Appendix A: Summary of Submissions and Responses to Issues Raised in Submissions

Swire Cold Storage Warehouse and Distribution Facility, Marsden Park (SSD 6799)

Discipline	CIVIL
Drawing No	2520460-96-0-606
Rev	A

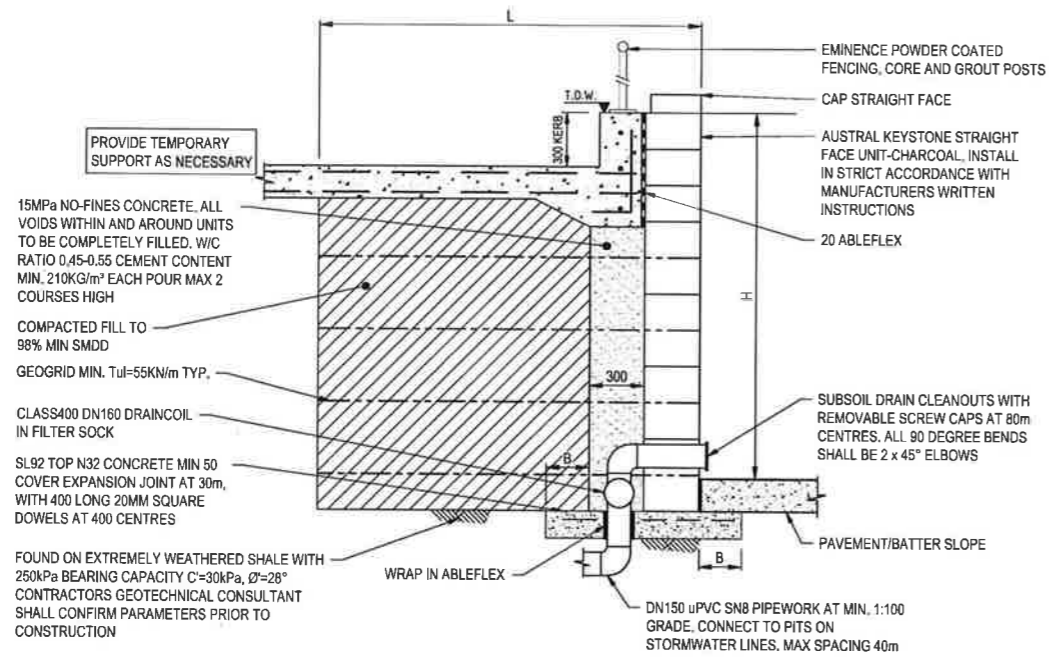
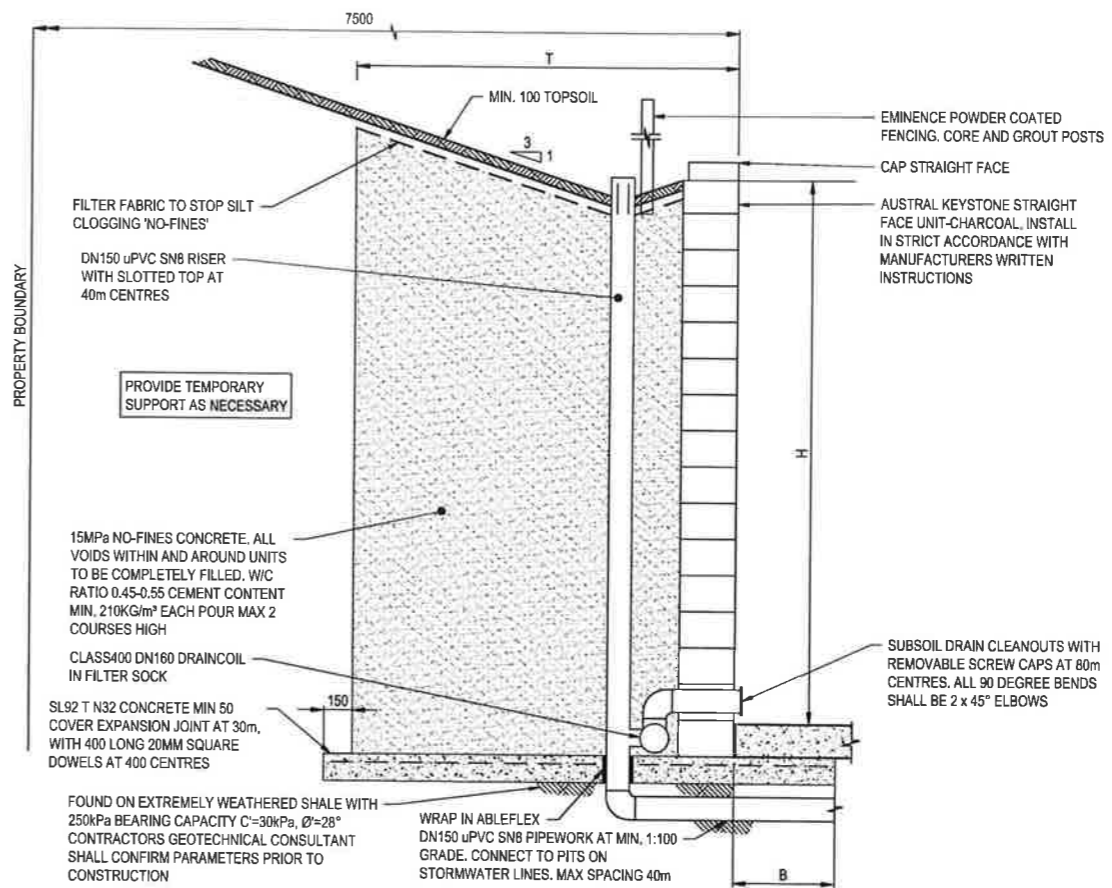
7(6)	Particular concern is raised with the elevation to Hollinsworth Road, which is a major collector road, the elevation is unacceptable in its current form as it is just a 'shed' with no mix of finishes, the building should have more masonry elements.	The Council's concern with the elevation to Hollinsworth Road is not understood. The building can be described a 'shed' by its very nature but the architectural treatment makes it a very smart 'shed' consistent with an industrial development of this type (refer to Item 3 above). Additional masonry elements would add further complexity to the building and considerable further capital and maintenance costs. It is difficult to understand how these would help.
7(7)	Full details of all boundary fencing and any retaining walls including materials of construction shall be submitted as a part of the application.	<p>The only boundary fencing is along the common boundary with Lindt on the east side. Elsewhere the fencing is set back behind the 7.5m landscaping strips and further within the property. The fencing details are shown on drawing 501 and meet the requirements nominated by Sydney Business Park.</p> <p>The details of the external retaining walls are shown on the Civil</p>

Issue no.	Key Issues Summary	Swire Response
		<p>drawings 604 and 607 submitted with the EIS. These are faced with Keystone charcoal straight face units being the standard set by Sydney Business Park. The retaining walls along the loading dock faces of the building (north and south sides) will be precast concrete.</p>
7(8)	<p>Concerns are raised regarding the "empty pallet" areas located towards Hollinsworth Road. No storage of any goods is to be permitted within the setback to Hollinsworth Road. Any external storage areas are to be fully screened to the full height of the goods to be stored. Any screening of storage shall not impede sight distances for trucks or vehicles. Full details shall be submitted as a part of the application.</p>	<p>The empty pallet areas at the NE and SW corners of the building are part of the building in that they are roofed and screened areas as indicated on the drawings submitted with the EIS.</p> <p>No storage is proposed in the open area between the building and the roads. The empty pallet areas do not impede the sight distances for trucks or other vehicles given this site have a one way traffic flow. Sufficient detail of the empty pallet areas has been provided to allow this application to be assessed.</p> <p>Full details will be available during the detailed design phase of the project which follows the EIS.</p>

Photomontage - View from Richmond Rd / Hollinsworth Rd Intersection

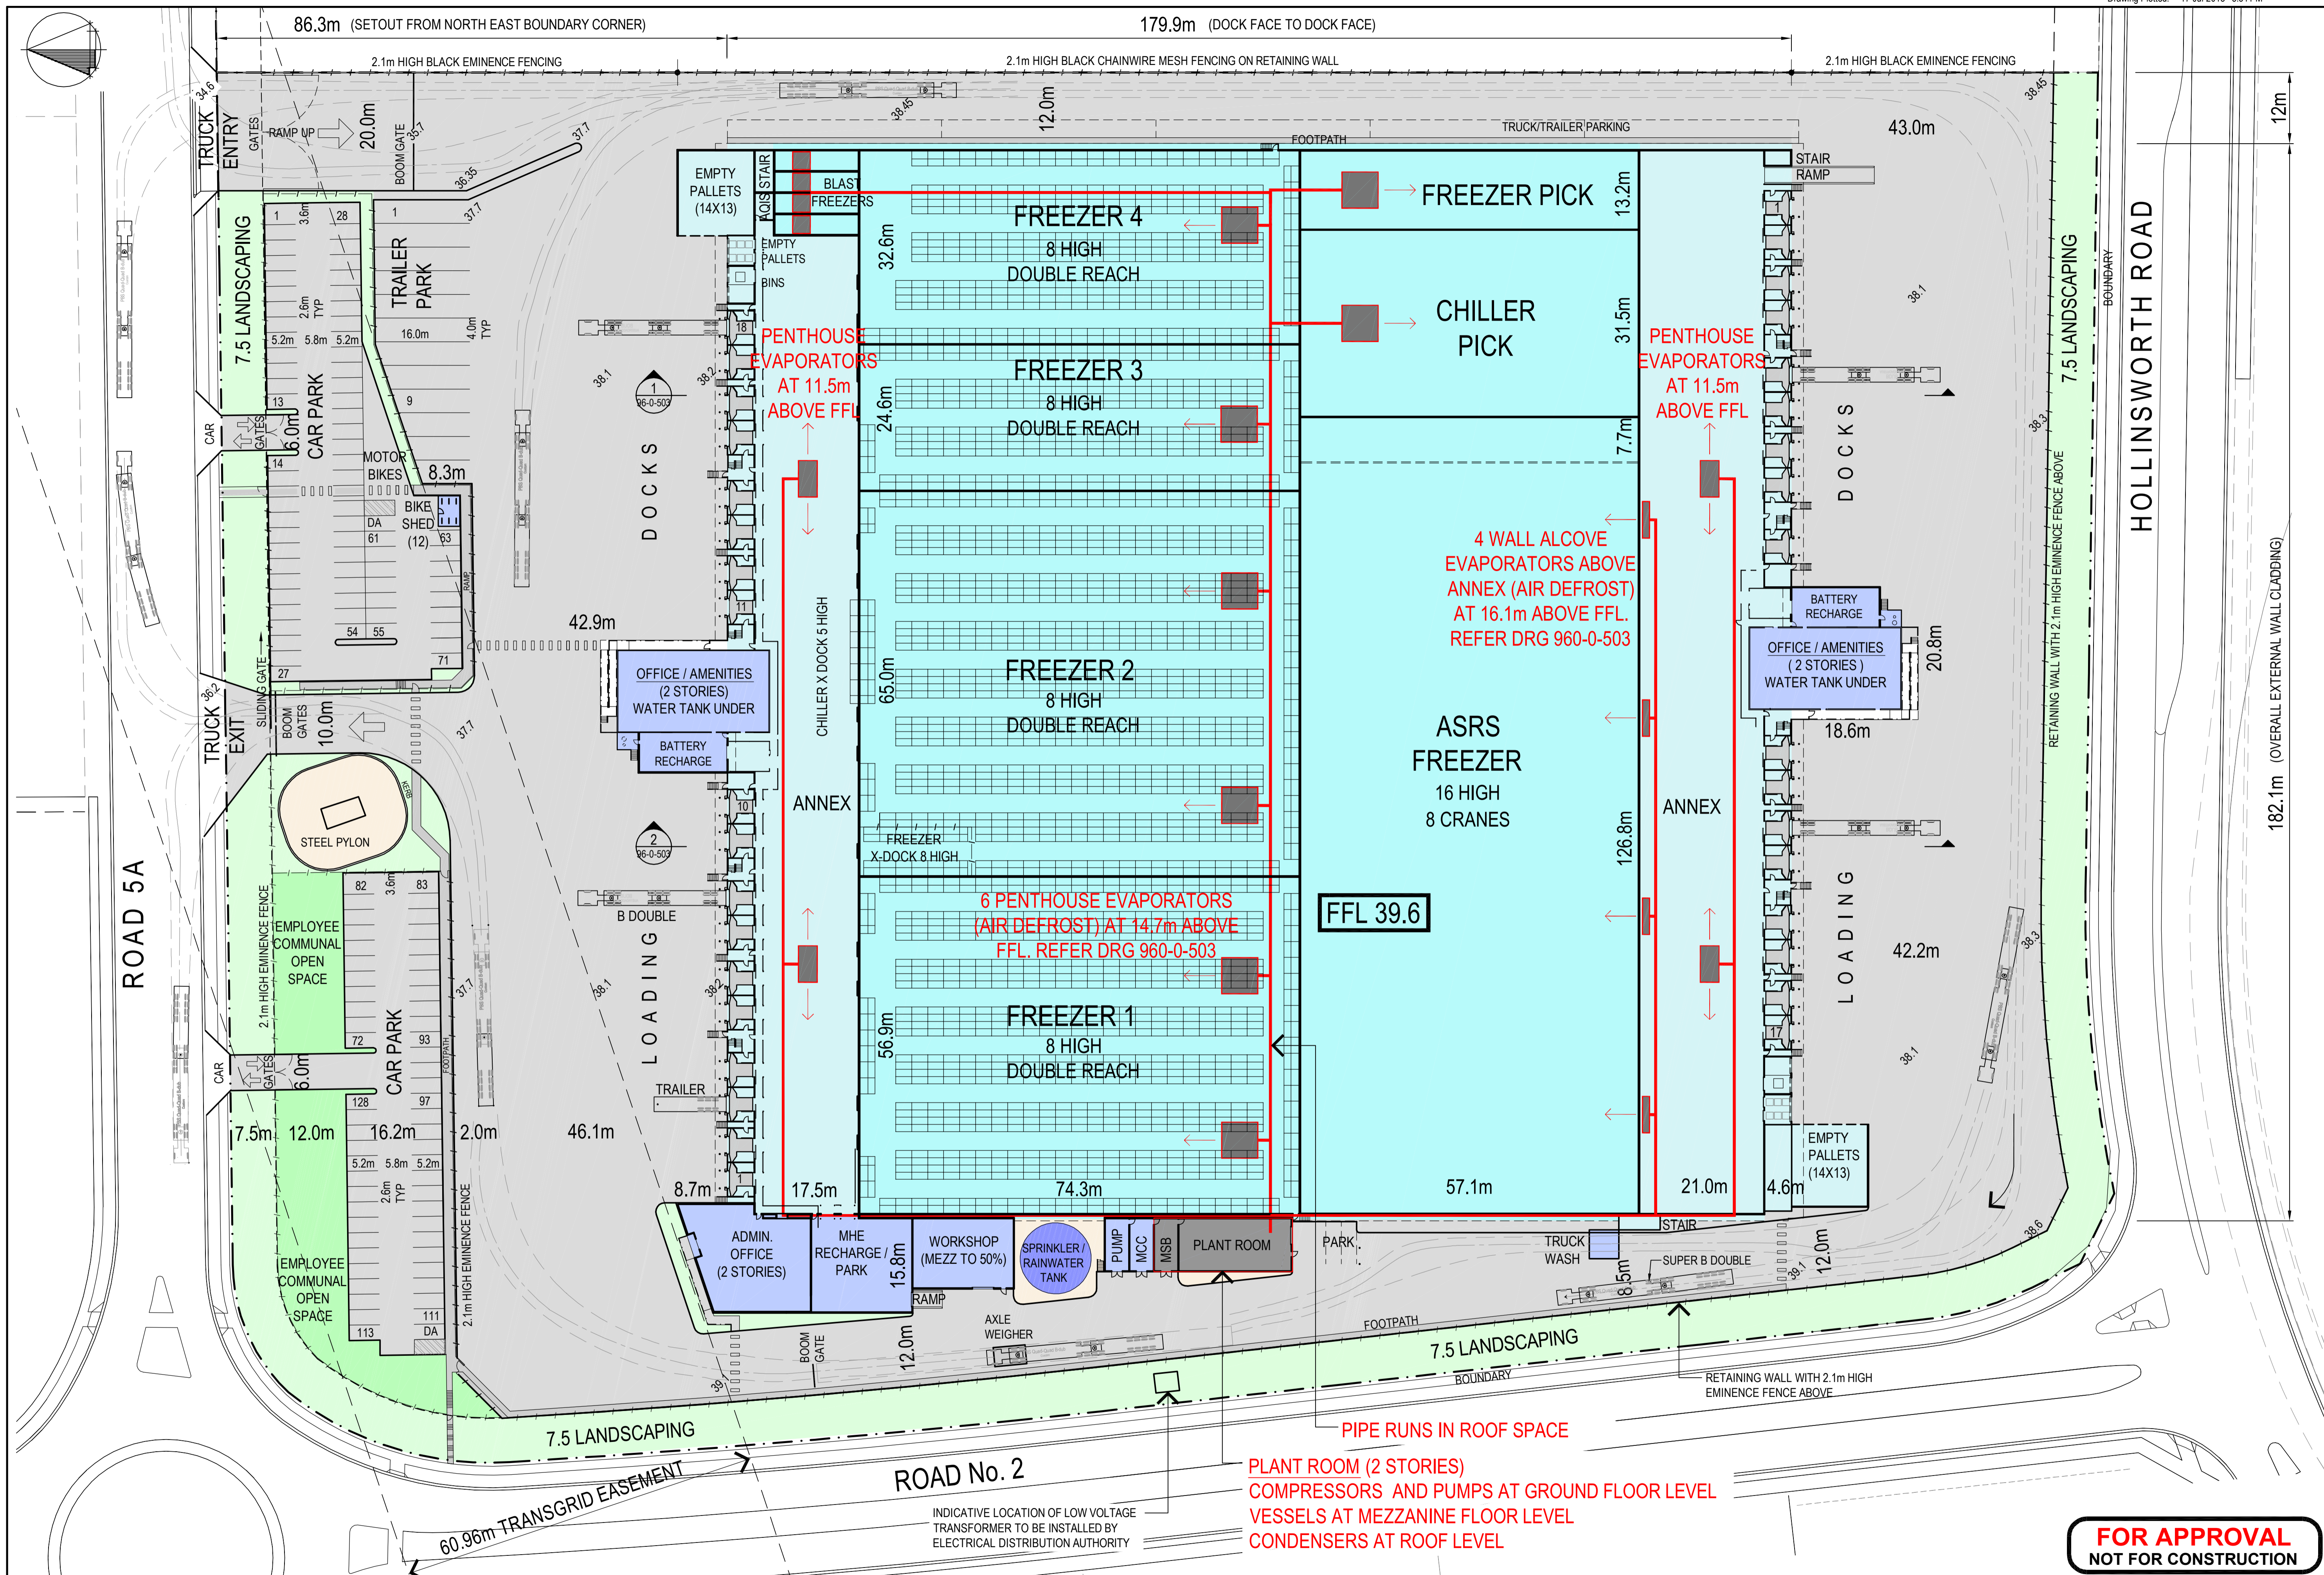
7(1d)	Further, no analysis or supporting information has been provided to demonstrate the effect of the proposed height variation in terms of impact on the skyline and views lost from Richmond Road when compared with a compliant proposal.	<p>A photomontage of the development viewed from the Richmond Road/Hollinsworth Road intersection was provided in the EIS submission (drawing 508 Revision B).</p> <p>A second photomontage has now been prepared showing a compliant height proposal (drawing 508C Revision A). As can be seen from the first photomontage, only the very top of the high-bay will be visible from Richmond Road compared with the second photomontage where the</p>

Issue no.	Key Issues Summary	Swire Response
		<p>building can't be seen at all.</p> <p>The additional height will not be intrusive and will barely impact on the skyline and views from Richmond Road where other closer buildings (including Bunnings, Ikea, and Masters) dominate the views.</p>
7(1e)	<p>No shadow diagrams have been submitted to demonstrate that the additional height proposed will not adversely impact any adjoining properties.</p>	<p>A shadow diagram has been prepared and is now attached (drawing 509 Revision A). This clearly demonstrates that the additional height has little added affect to the shadow cast across the boundaries of the site and will have minimum impact on the adjoining properties.</p>
7(1f)	<p>It has not been demonstrated that the proposed design of the development exhibits a high quality built form in an appropriate location in accordance with the relevant objectives (b) and (d) of the Height of Building standard.</p>	<p>Contrary to Council's statement, it is considered that the proposed design does exhibit a high quality built form for this location and the submitted drawings and statements support this claim.</p> <p>Even the second submission to Council had a visual treatment that surpasses all Swire cold store facilities in other Australian cities and we would expect to be at least be equal to any other large cold store facilities in Australia.</p> <p>The third submission to Council (on which the current design has been based) has a particularly responsive treatment that is considered to significantly surpass other facilities and takes cold store design to a new architectural level.</p> <p>The architectural enhancement between the second and third submissions to Council has a significant additional capital cost tag (in excess of \$1M) which significantly impacts on the commercial viability of the development in this very competitive industry. While Swire is very supportive of having a high quality development consistent with Council's objectives for the Estate, they are also very conscious that their competitors in other locations in Australia are not incurring similar cost premiums.</p>
